**Consultation Response from KC,
Highways Development Management****2025/91370 Land at, Gynn Lane, Honley, Holmfirth, HD9 6LF****Demolition of existing dwelling and erection of 50 dwellings with associated access,
infrastructure and associated works****Date Responded:08/08/2025****Responding Officer: Ryan Kinder****Responding Ref:K3-50/25**

2025/91370 Land at Gynn Lane, Honley
Highway Development Management's (HDM) comments for the above application as follows:

RECCOMENDATION: Objection – further information required.

25m FORWARD VISIBILITY

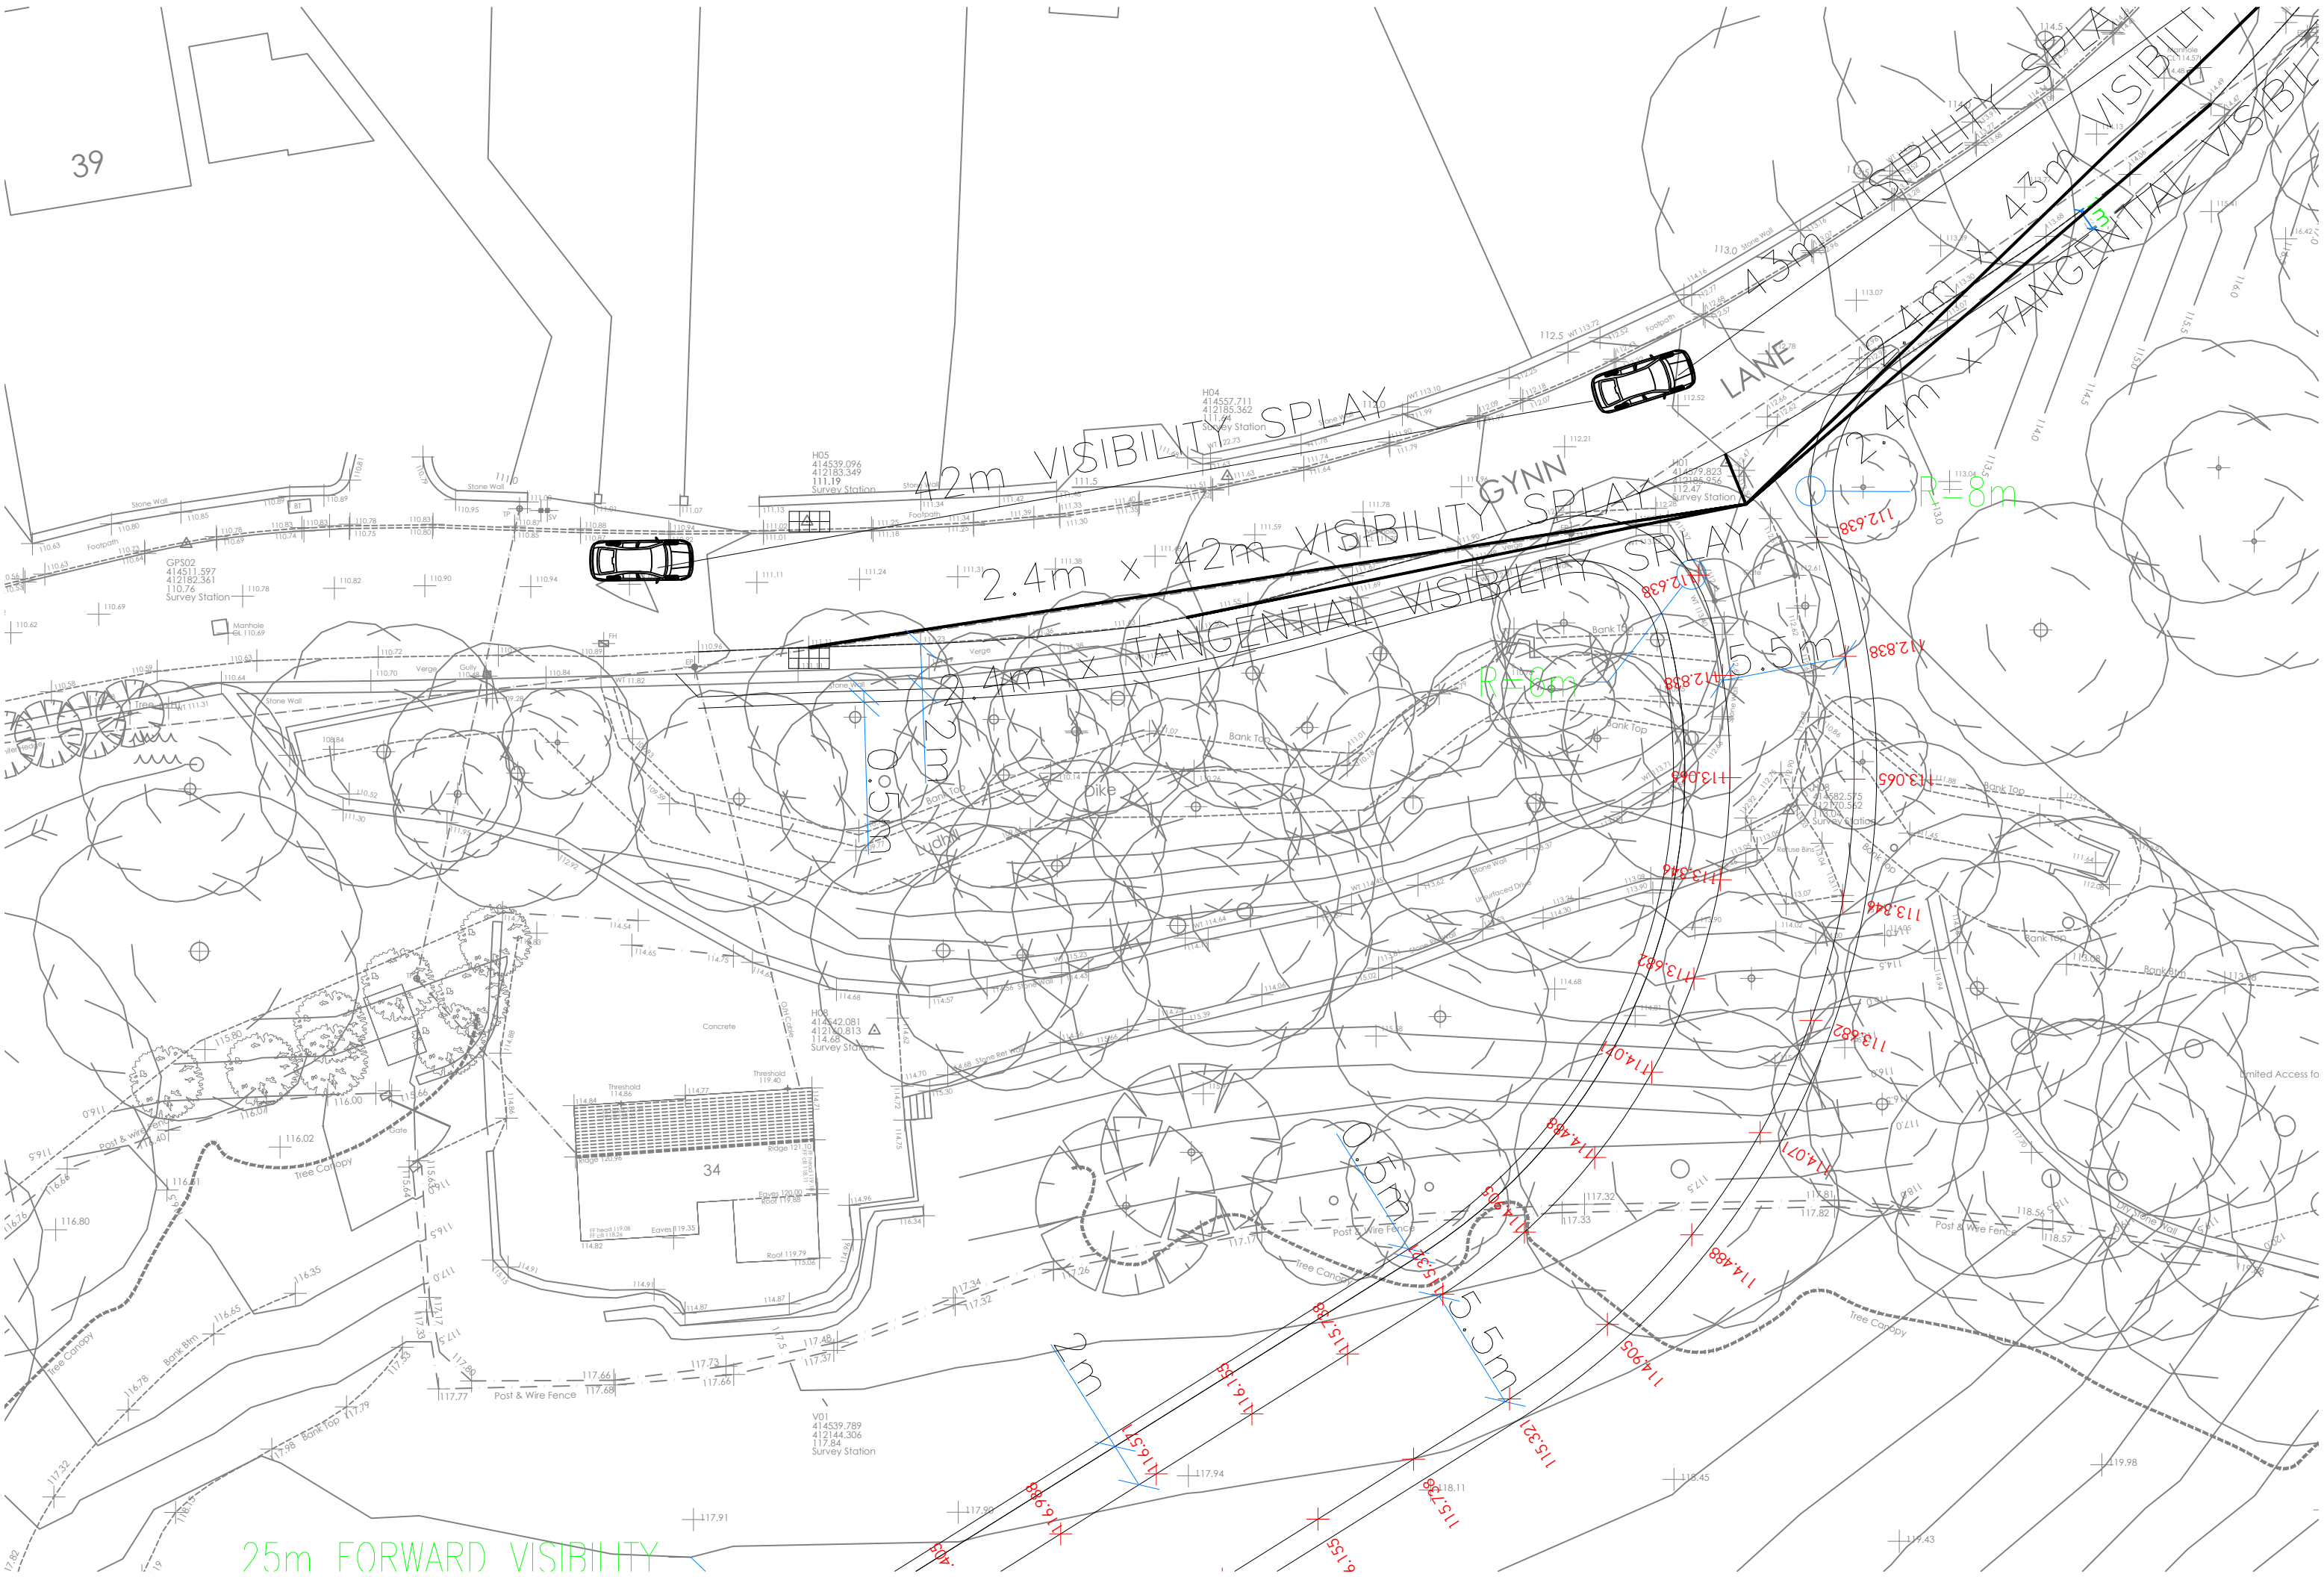
Visibility splays and forward visibility envelopes have been demonstrated and achievable within the Highway, these are considered acceptable.

A 20m centreline radius for bends on the internal layout should be provided.
